PROPOSED NORTHCONNEX M1 / M2 TUNNEL PROJECT - Application Number - SSI 13_6136
We object to many aspects of this project

SUMMARY OF CONCERNS IN RELATION TO THE PROPOSED NORTHCONNEX TUNNEL

SECTION A: THE CONNECTIVITY OF NORTHCONNEX SOUTHERN VENTILATION FACILITY AT THE SOUTHERN INTERCHANGE, THE SOUTHBOUND TUNNEL IN PARTICULAR

MOTORWAY OPERATIONS COMPLEX - SOUTHERN VENTILATION FACILITY - SECTIONS
M1-M2-5000-DR-JD-0525

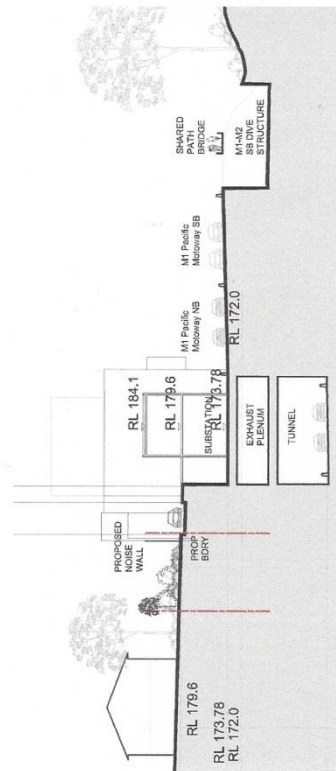
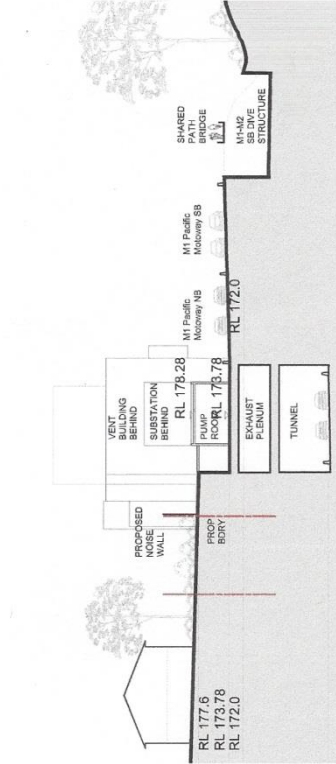
5. *EIS Volume 4, Technical working papers - Urban Design, 6.0 Operational Ancillary Facilities*
EIS Page 99 there is the diagram "Motorway Operations Complex – Southern Ventilation Facility – sections. *Page 10 below* The diagram has the cryptic label "Connection to tunnel TBC". What does TBC stand for? To be considered? Why is tunnel singular? Which tunnel is the diagram referring to northbound or southbound? There is no diagram showing any connection from the Southern Interchange ventilation facility to either the northbound or the southbound tunnel in any way AND YET

- Diagrams need to be provided showing the inter-relation between the shaft, the ventilation outlet and the motorway operations centre with a clear description of what is to be constructed and how it will operate.
- The community needs irrefutable evidence that the polluted air from the southbound tunnel exit portals will not be allowed to flow like an invisible sewer through West Pennant Hills, North Rocks, Carlingford and Beecroft.

Figure 5-14 Indicative tunnel ventilation system (northbound tunnel arrangement)

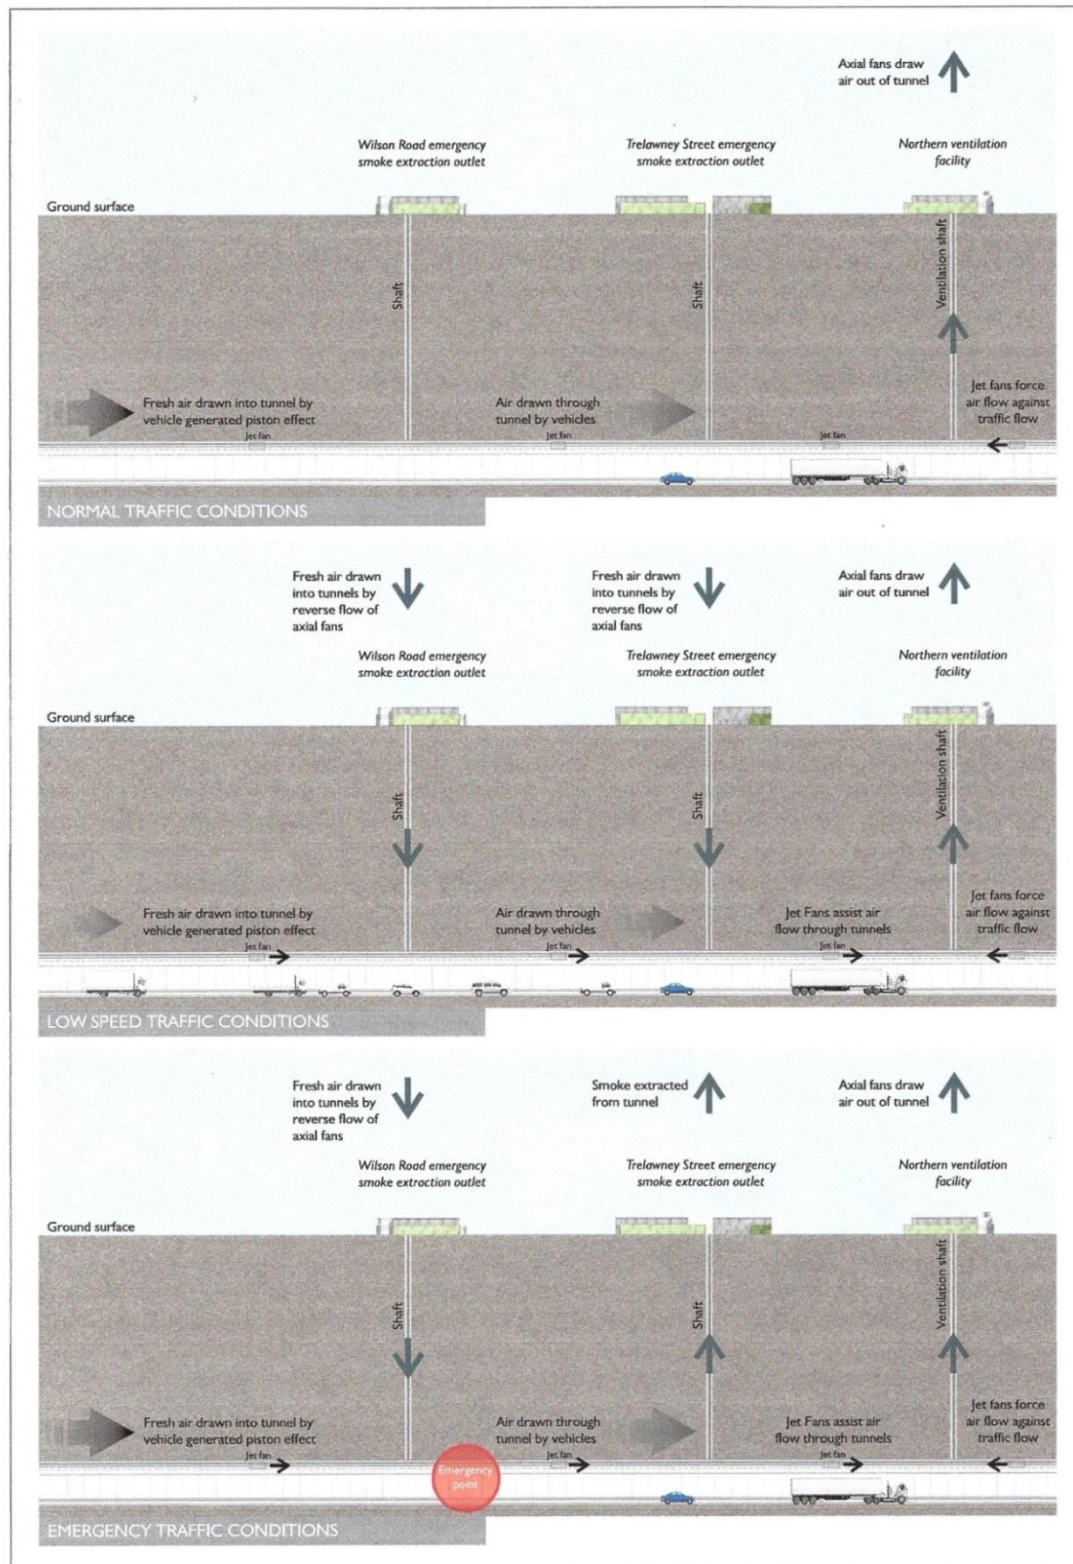
Page 4 below this is a clear diagrammatic depiction of how the Wilson Road, Trelawney Street and Northern Ventilation facilities are connected and how they will work.

There is no such diagram to illustrate how the Southern Ventilation facility is connected and how it will work given that it is across the road and 250 metres (m) from the southbound exit portal onto Pennant Hills Road and approximately 250m from the south-west exit portal onto the M2.

Figure 5-17 Motorway operations complex

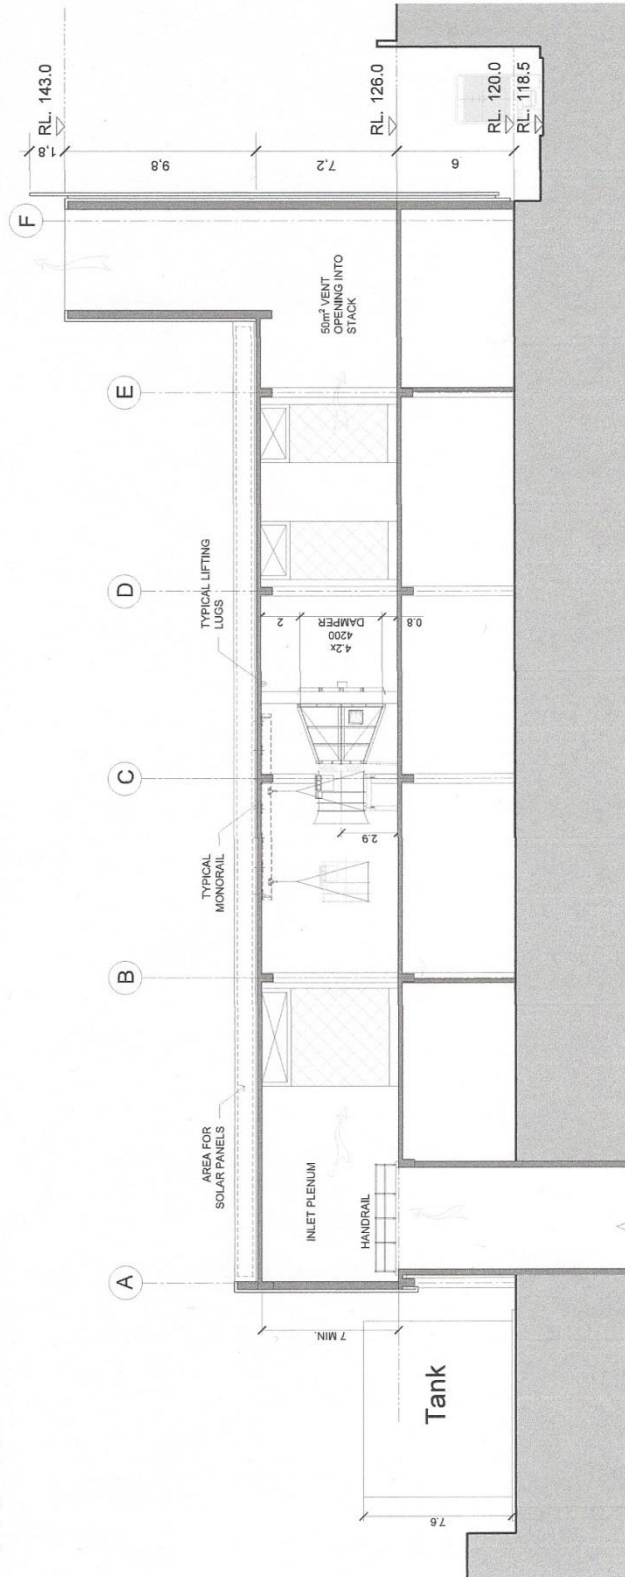
Page 8 below there is no indication of how the ventilation facility will be connected to either the northbound or southbound tunnel, nor is there any indication of how the southbound exit portal onto Pennant Hills Road or the south-west exit portal onto the M2 will be connected.

In each of the above figures for Wilson Road, Trelawney Street, and Northern Ventilation facility, the shafts, emergency smoke extraction buildings, and ventilation facility make a substantial footprint in the construction area; however for the Southern Interchange the ventilation facility is an insignificant part of the construction area. How can this be? The difference in scale does not explain the difference.

We also find it disturbing that in each of the above figures for Wilson Road, Trelawney Street, and Northern Ventilation facility the headings are for “*tunnel support facility operational layout*” and “*ventilation facility operational layout*” but for the Southern Interchange the description is for “*Motorway operations complex*” with no mention of the ventilation facility or the tunnels.

Figure 5-38 Indicative southern interchange construction compound

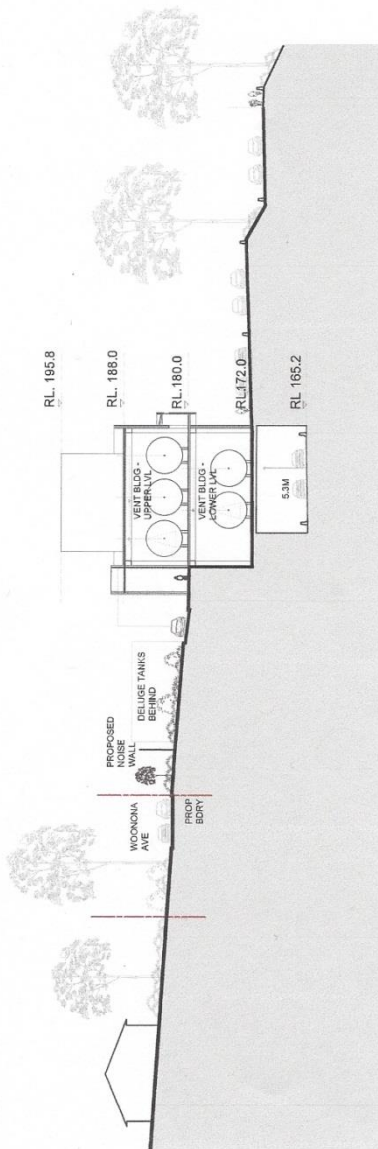
It is ominous that the southern ventilation facility and shaft are completely absent from Figure 5-38.
